## **TOGA CENTRAL - DESIGN INTEGRITY PROCESS – RTS DESKTOP REVIEW**

This letter has been prepared on behalf of the Design Integrity Panel (**DIP**) for the TOGA Central State Significant Development (**SSD**), in relation to the design integrity process following the desktop review of design information on 23 November 2022.

**TOGA Central**  
Design Integrity Panel  
Notification of design  
adjustment  
fPPb Atrium shape

fPPb - Typical upper floor - revised design

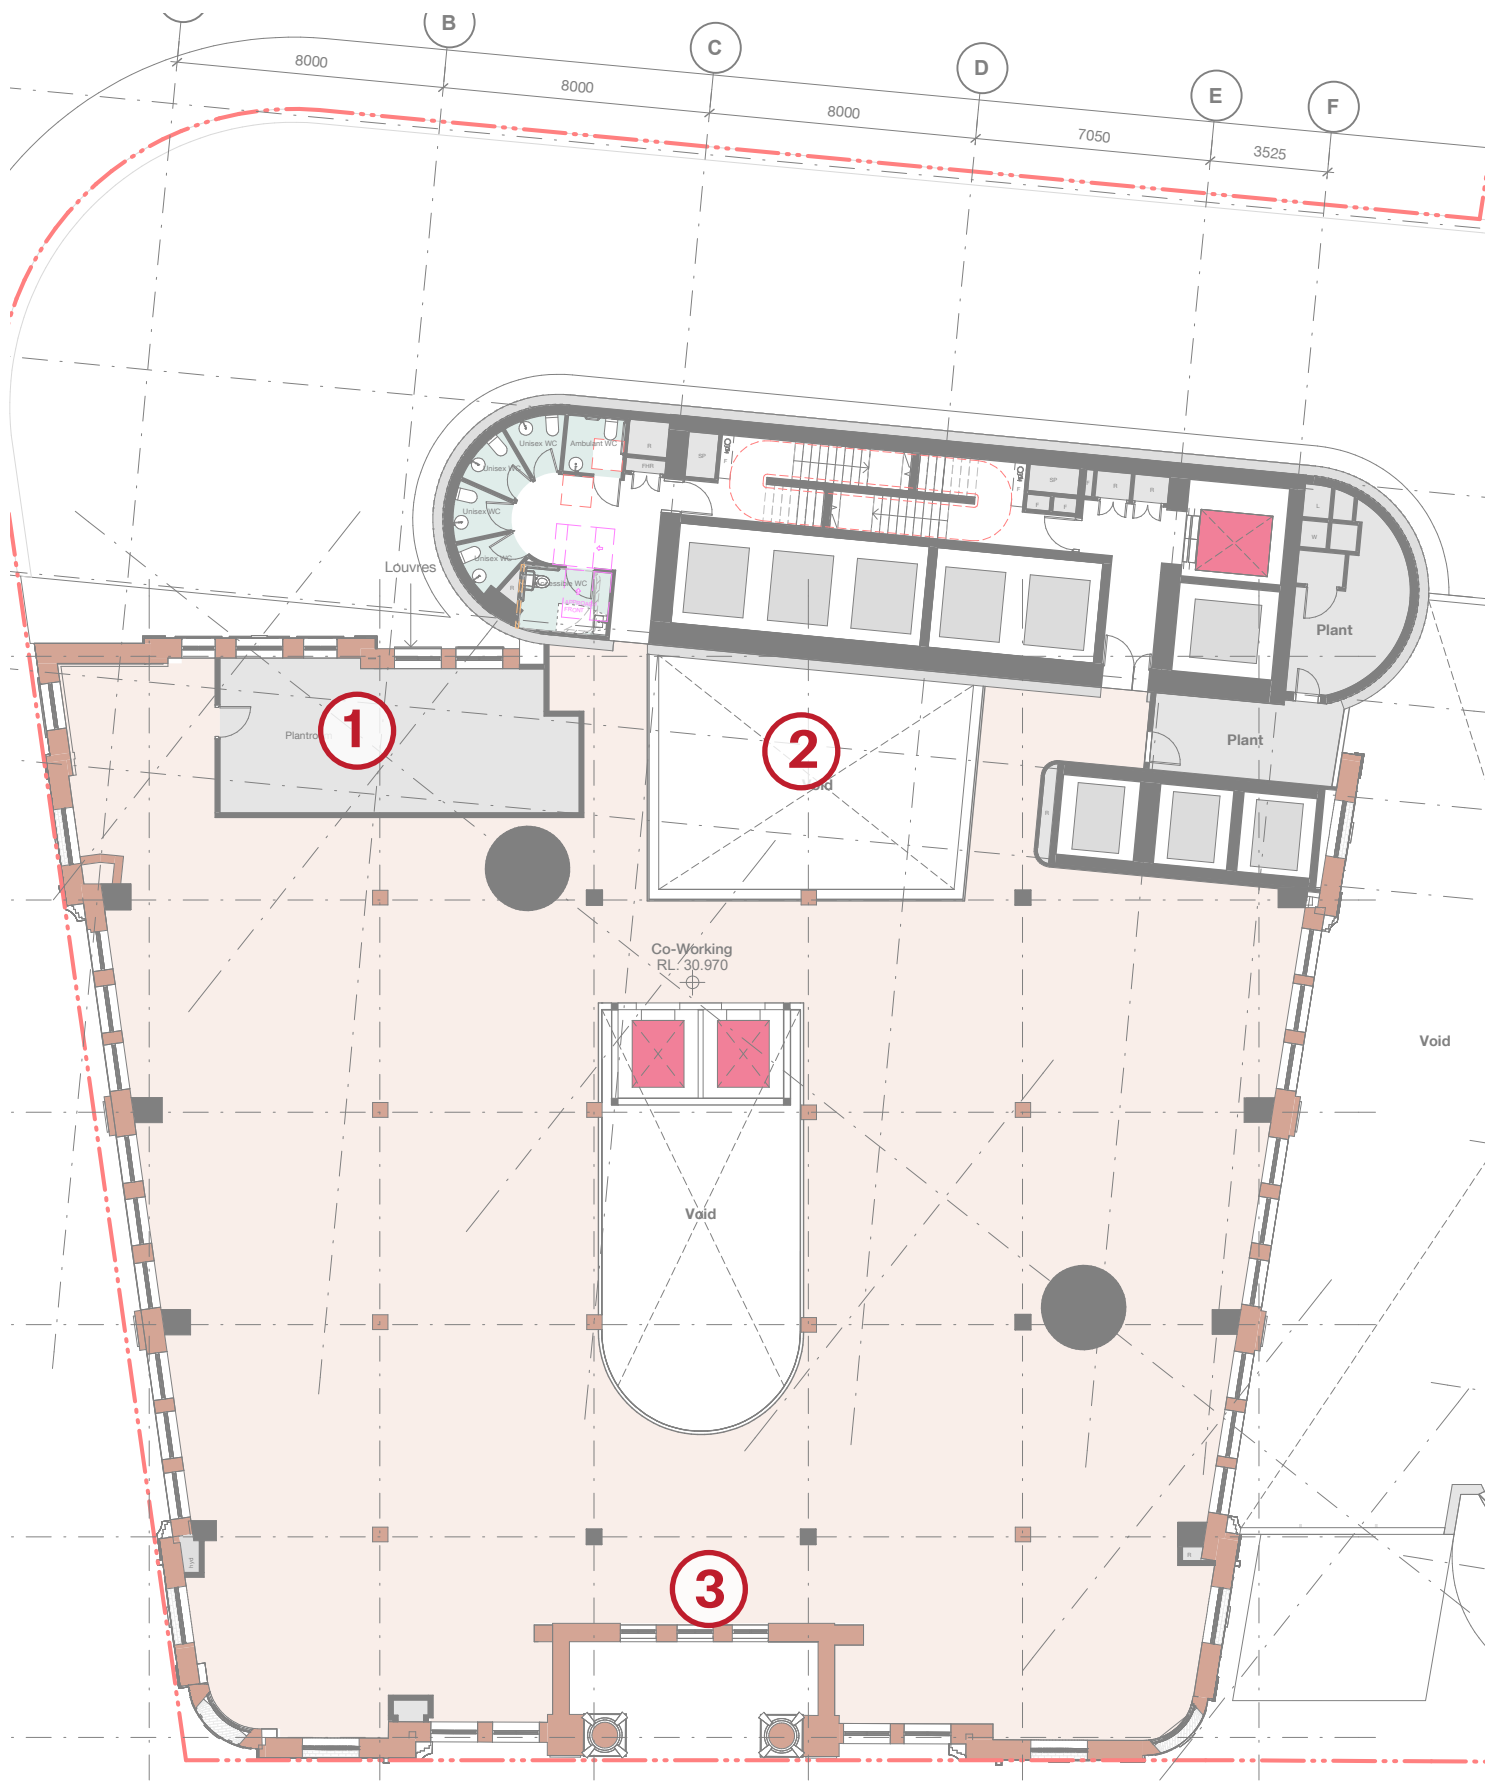
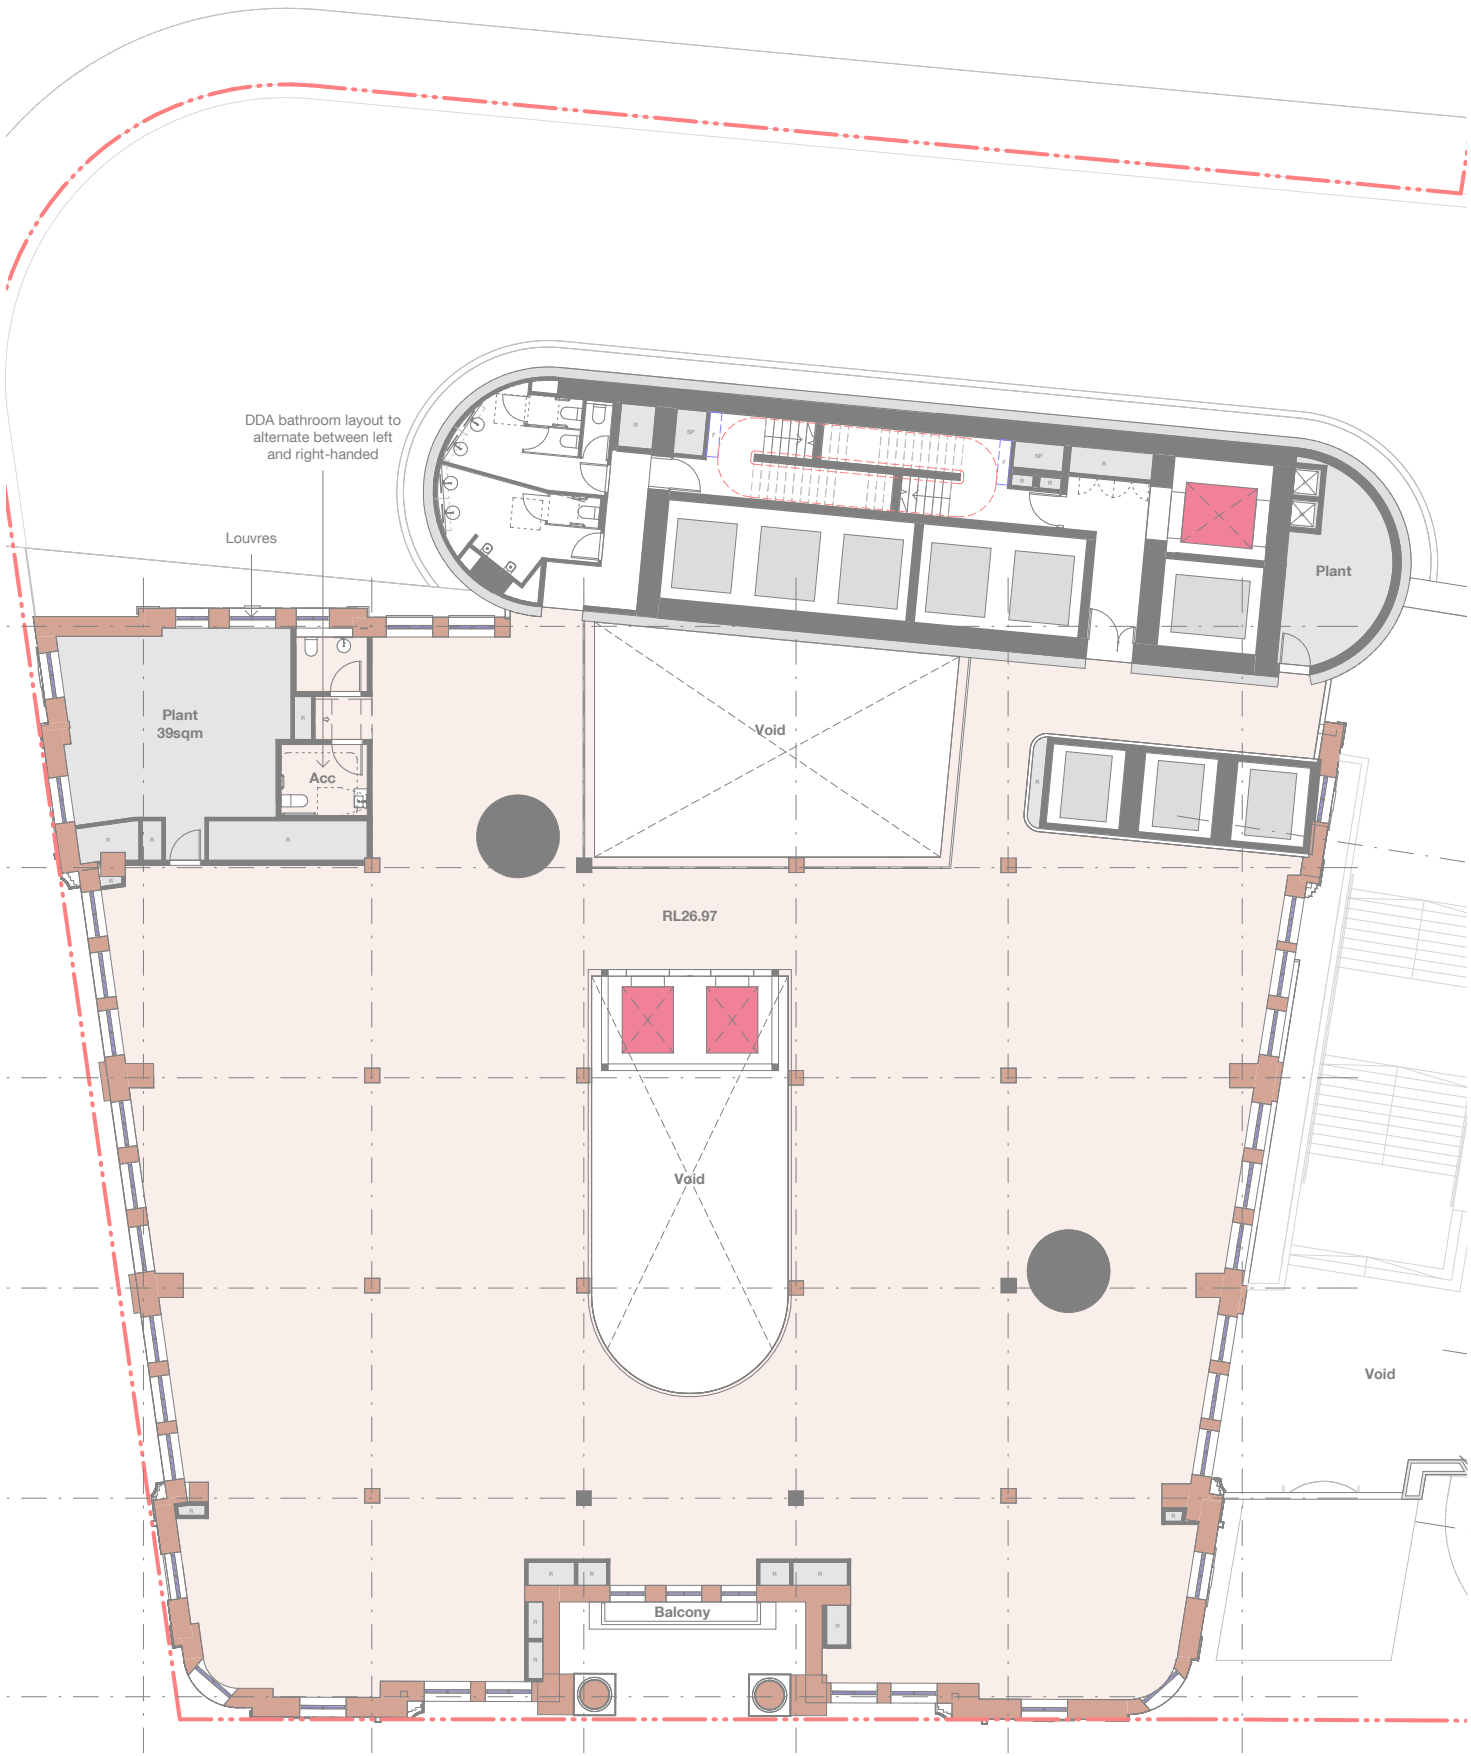
The RTS seeks to rationalise the design of the central atrium located within the fPPb to match the shape of the void on the floors above, providing a more consistent expression throughout the building and acknowledging the existing structure of the heritage building. This is outlined in the DIP Heritage Atrium Update package prepared by Bates Smart and provided at **Attachment A** to this DIP letter.

The DIP support the reconfigured atrium within the fPPb and roof level.

Ground floor plan - revised design

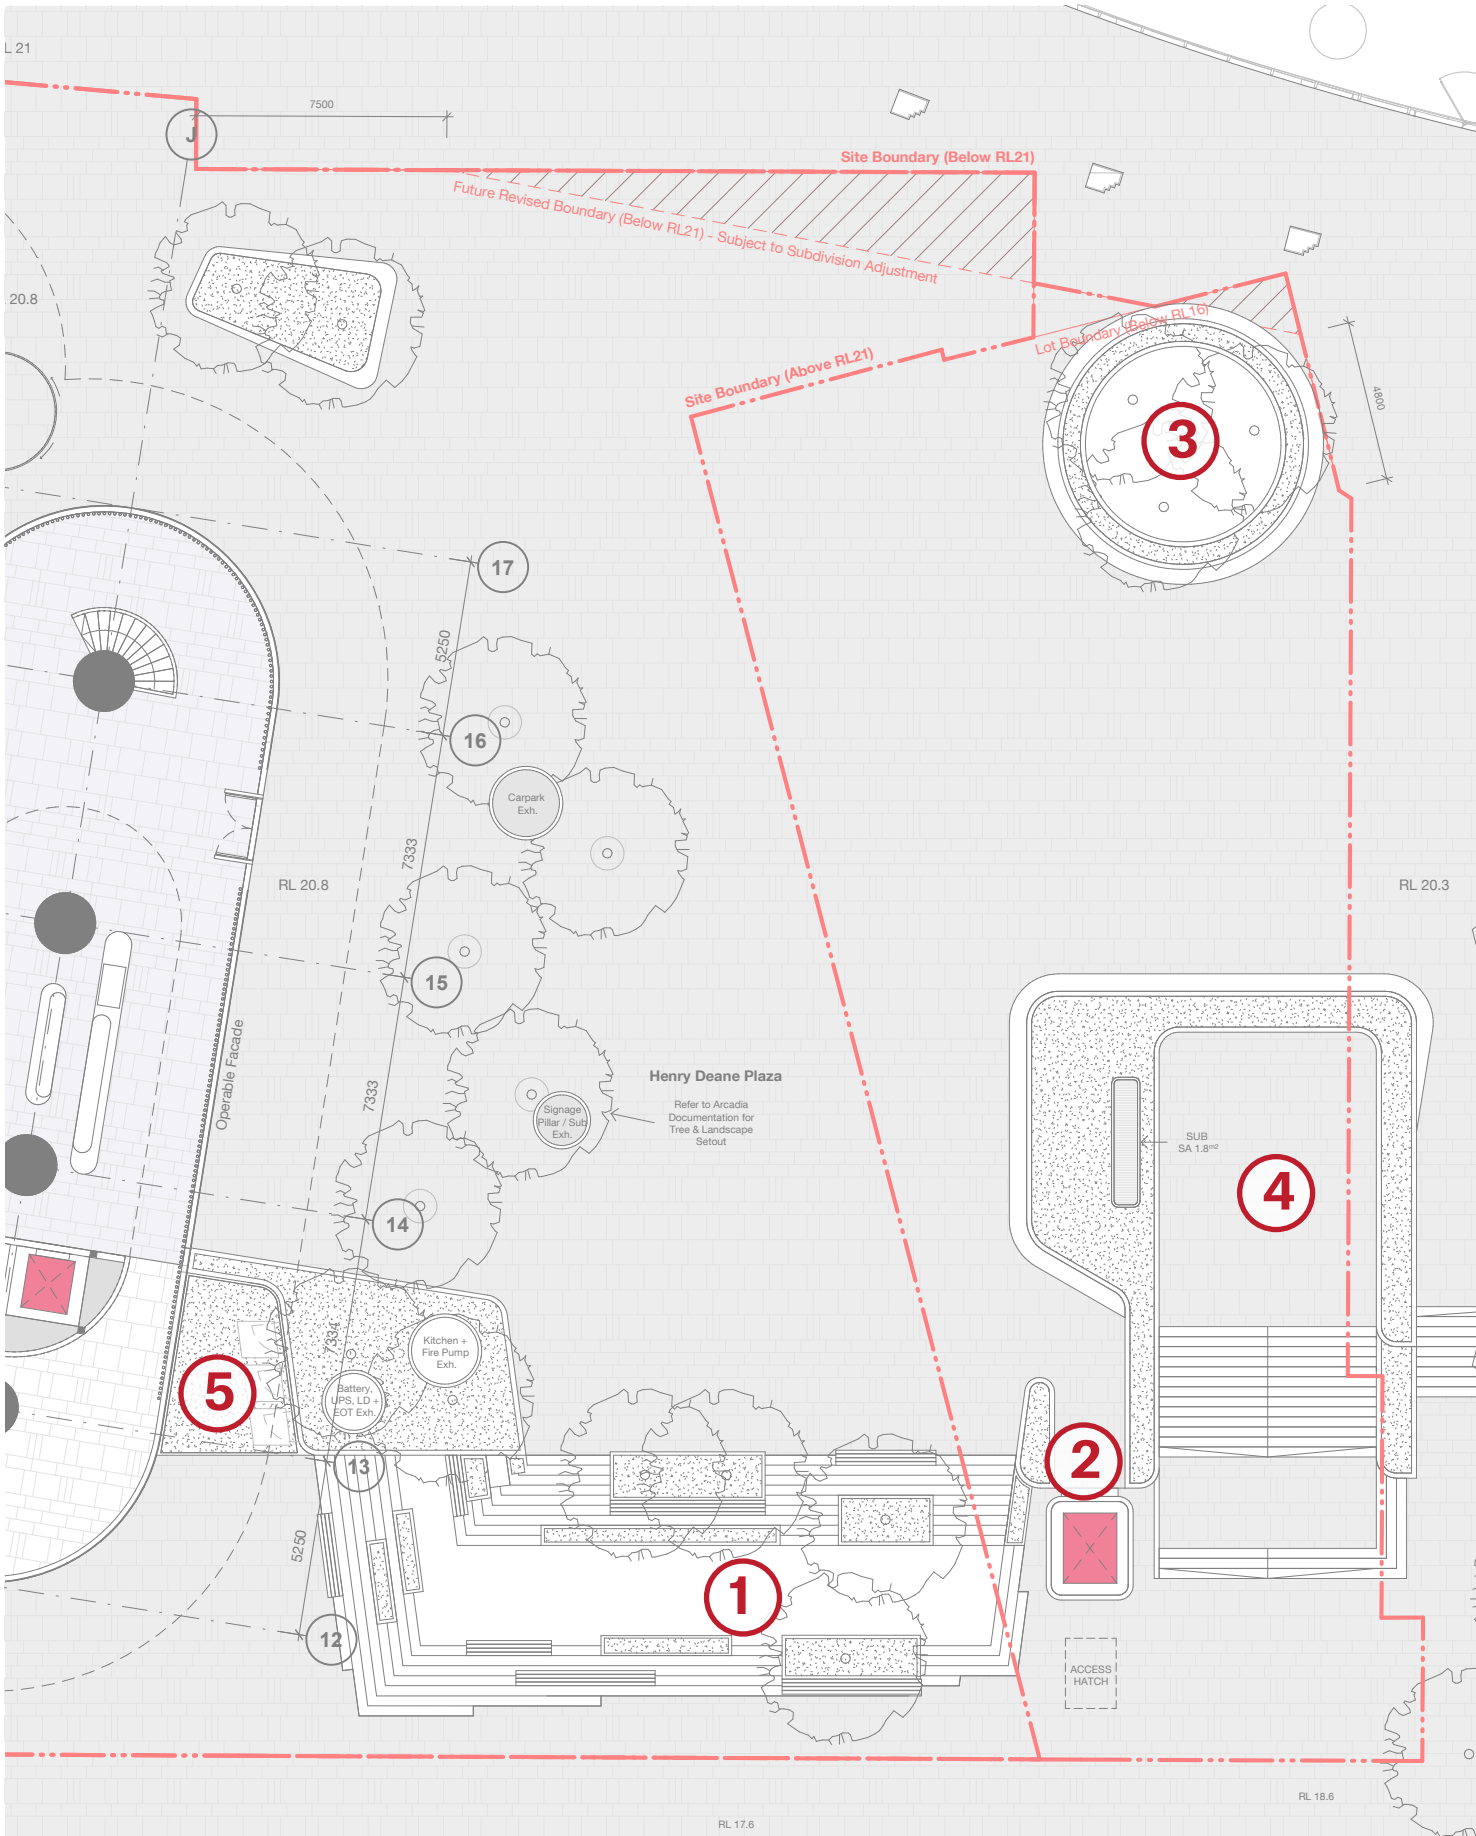
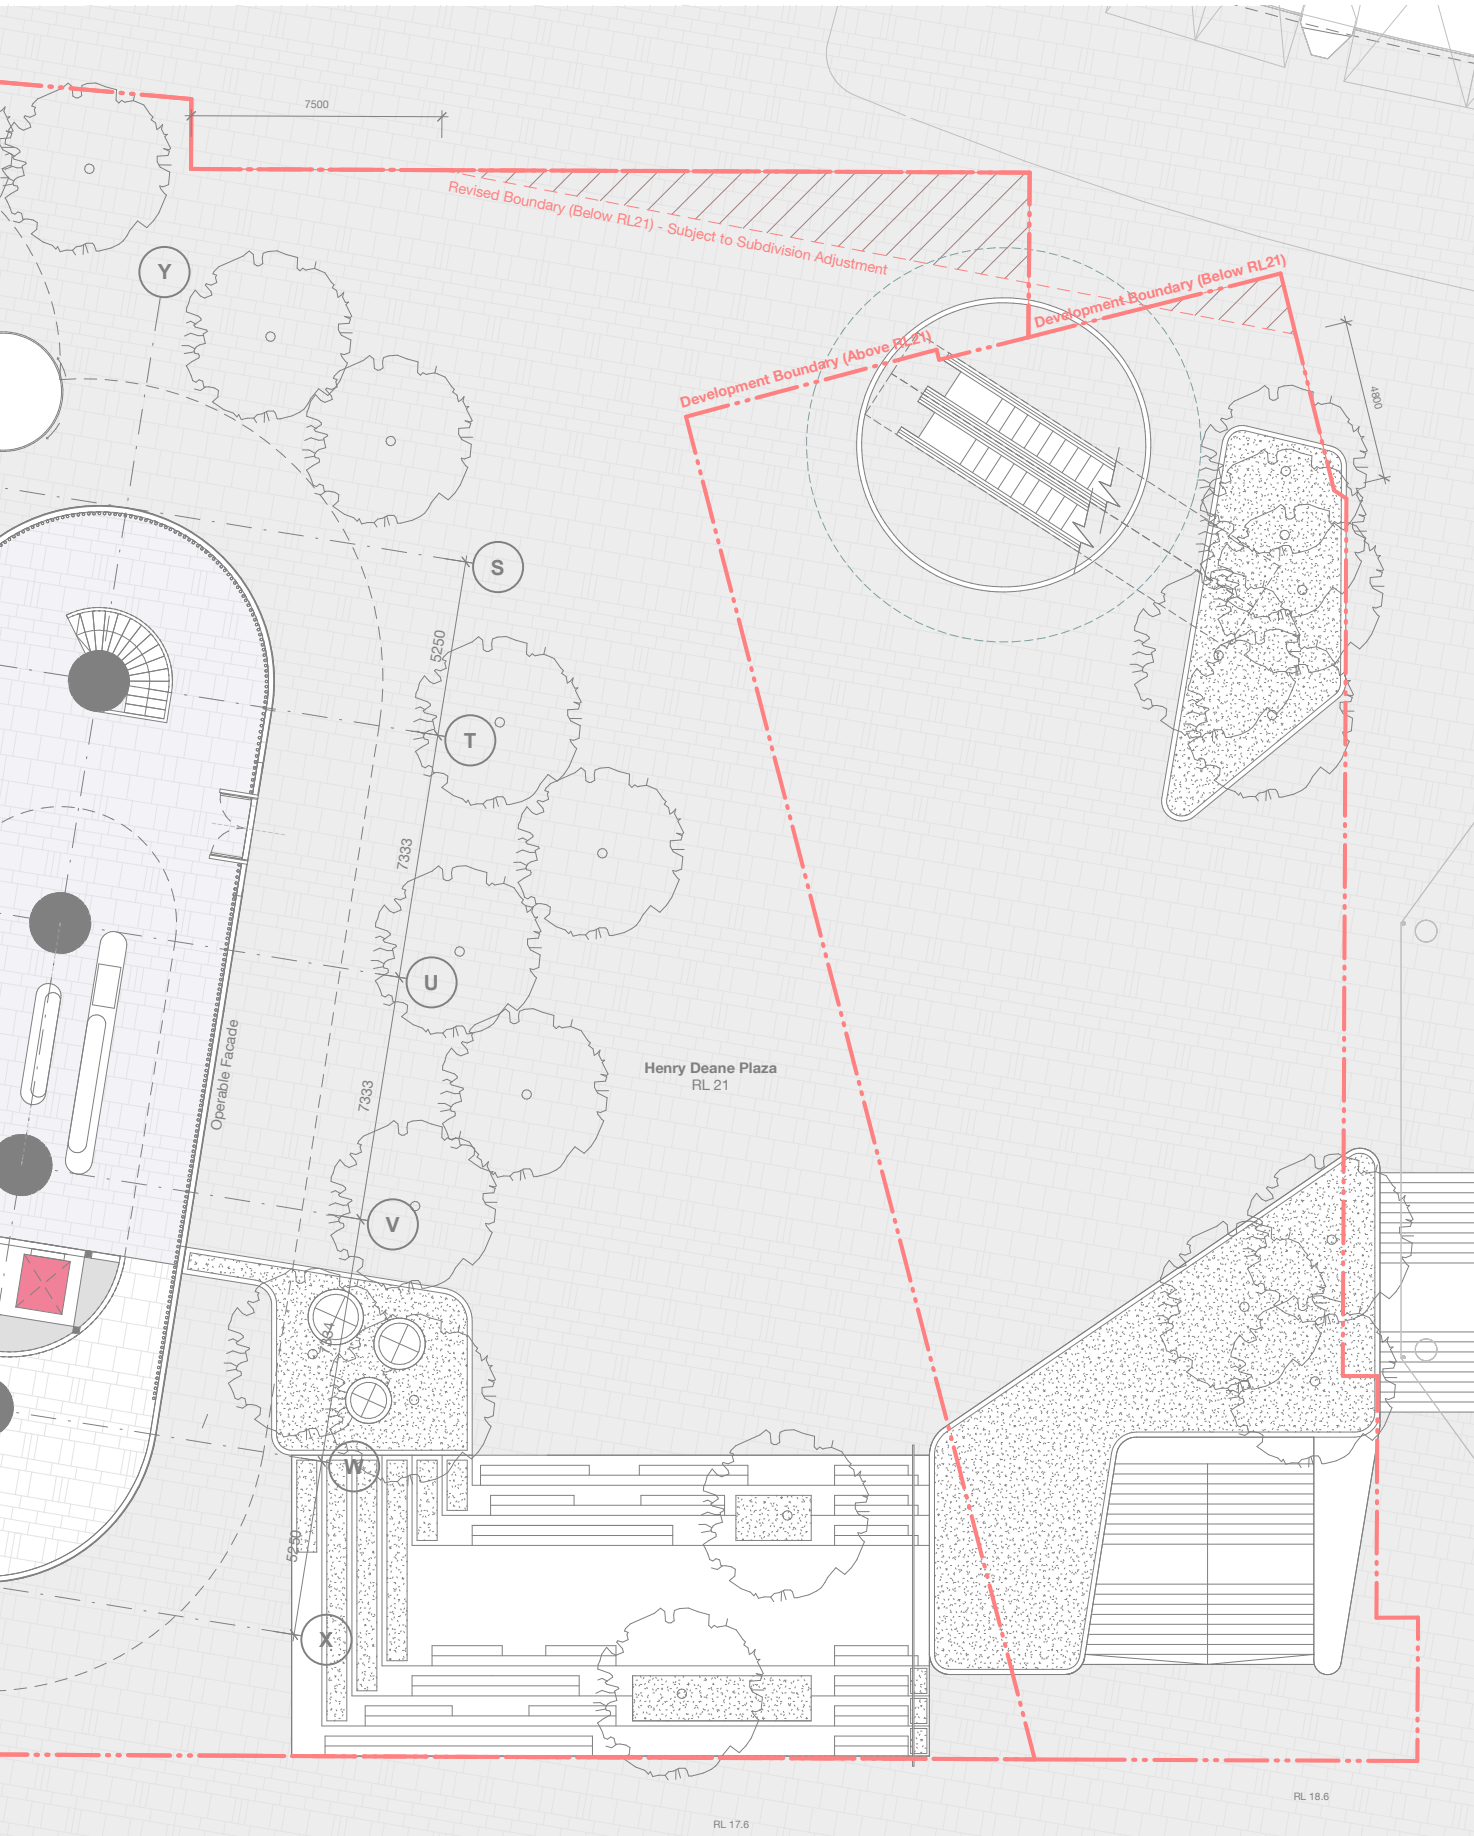
- The ceiling in the lower ground level is to be developed to maximise the light and animation in the space below.
- Ongoing coordination with the Dexu Frasers Consortium on the coordination of the public domain design in Henry Deane Plaza.
